Application Ref:		3/2026/0436		 Ribble Valley Borough Council www.ribblevalley.gov.uk
Date Inspected:	NA	Site Notice:	NA	
Officer:	LOH			
DELEGATED ITEM FILE REPORT:				APPROVAL

Development Description:	Certificate of Lawfulness for a proposed single-storey rear extension.
Site Address/Location:	19 Tootle Drive Longridge PR3 3UH

Site Proposed

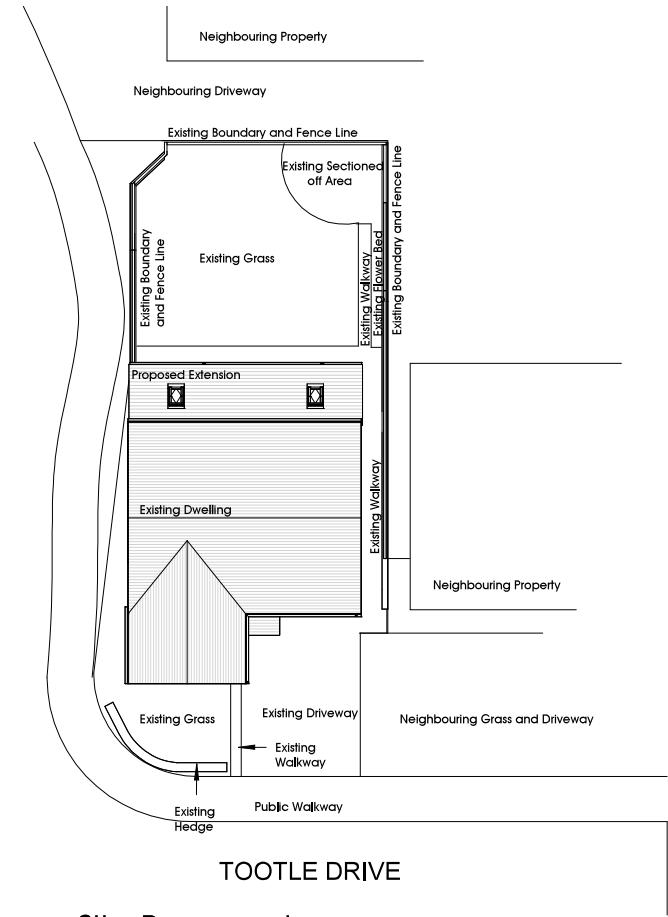
The single-storey extension would not exceed 50% of the total area of curtilage of the property.

Proposed  
Floor Plan and Elevations

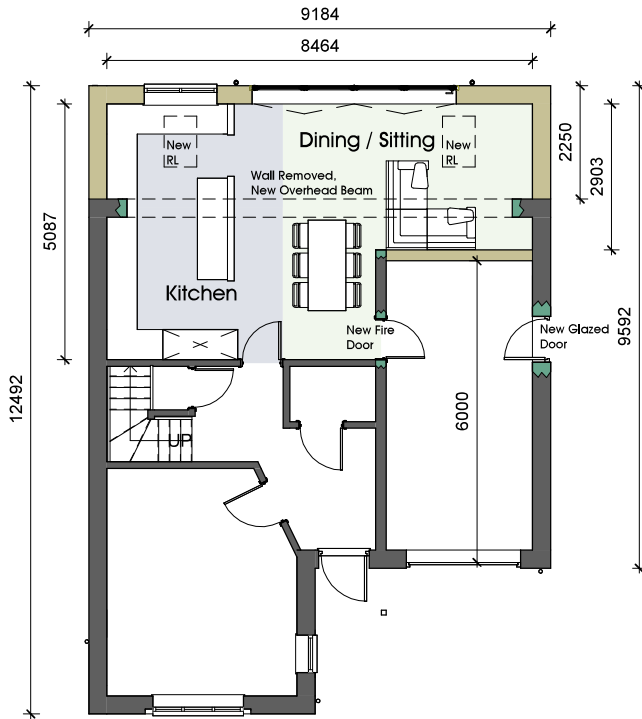
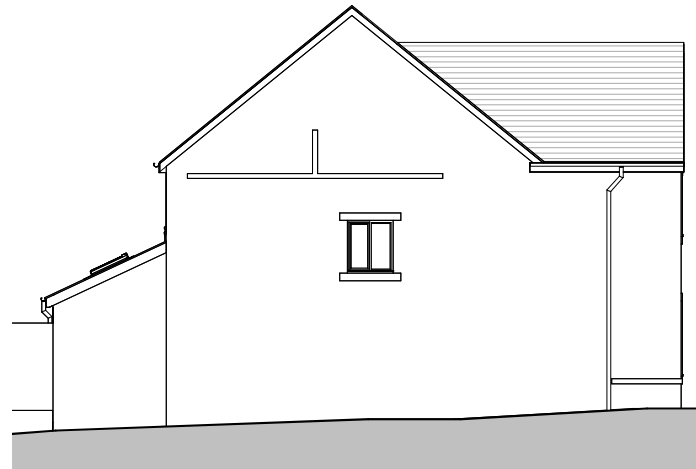
ASSESSMENT OF PROPOSED DEVELOPMENT:
Site Description and Surrounding Area: The application relates to a detached two storey dwelling house, known as 19 Tootle Drive. The site lies within a residential area within the settlement area of Longridge.
Proposed Development for which consent is sought: Consent is sought for a Certificate of Lawfulness for the erection of a single-storey extension. The proposed extension would project out from the dwellinghouse's rear elevation by 2.25m, with a width of 9.18m and an eaves and ridge height of 2.37m and 3.45m respectively.

The height of the proposed single storey extension would not exceed the height of the existing dwelling

The height of the eaves of the proposed extension would not exceed the height of the eaves of the existing dwellinghouse.

The proposed rear extension does not extend beyond the rear elevation of the original dwelling by more than 4m or exceed 4m in height.

The enlarged part of the dwelling house is within 2 metres of the boundary of the curtilage, however the height of the eaves does not exceed 3 metres.

The proposed extension would not extend beyond a wall forming a side elevation of the original dwellinghouse.
